## DECISION DELEGATED TO DEVELOPMENT MANAGER

**Application No:** H17-0578-20      **Applicant:** Mrs M Ward

**Proposal:** Details of scheme to deal with contamination, windows and doors, brickwork/mortar and floor levels/flood risk report (Conditions 3, 6, 7, 8 & 10 of H17-1152-19)

**Location:** La Castagna Cheal Road Gosberton

TYPICAL DOOR AND FRAME SECTION

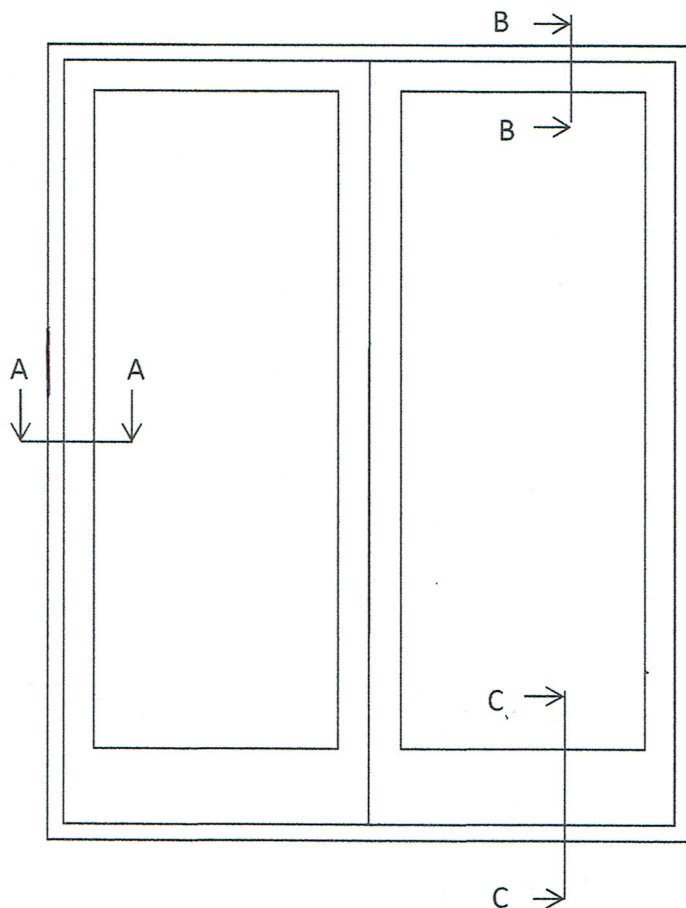
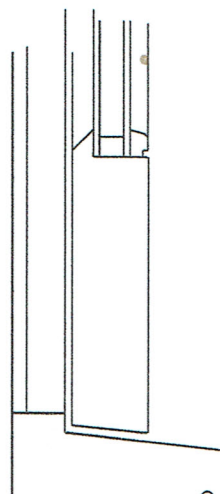
Condition 6 (door details) - Submitted details are acceptable.
